# City of Albuquerque Stormwater Construction Site Inspection Report

Project Name:	Montecito Vistas				
Location:	Vista Vieja				
Site Contact Name & Agency	Troy/Dan - Pulte	ESC File No.	D09E005		
	<a href="mailto:troy.crutchfield2@pulte.com">troy.crutchfield2@pulte.com</a>	NPDES Id. No.	NMR100BZ		
Inspection Date:	01/16/20	Start/End Time:	0810/0900hrs		
CoA Stormwater Inspector:	Timothy E. Sims				
Construction Phase:	home construction				
Type of Inspection:	<input checked="" type="checkbox"/> Regular	<input type="checkbox"/> Storm Event	<input type="checkbox"/> Post Storm Event >0.25"	<input type="checkbox"/> 311/Complaint	<input type="checkbox"/> Follow Up

CUT BACK CURB DETAIL
NOT TO SCALE

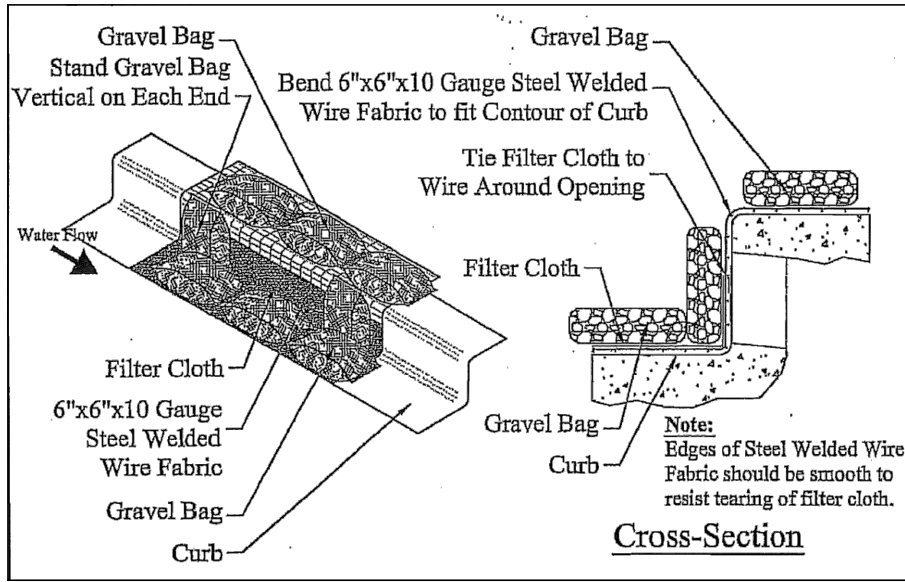
Item Number	Deficiency/ Corrective Action		
1	Waste not in accpetable container. Please place all waste in refuse bins.		
2	Washout not in acceptable facility; mortar washout, curb cut slurry, and concrete washout litter several lots. Please mitigate and prevent in the future.		
3	Please provide curb cut cutbacks at drive pads.		
	***Please provide latest SWPPP self-inspection report		
2.1	Discharge off site? (Y/N)	No	
4	Self Inspection Reports	requested	Latest report Date: 9/2/2019
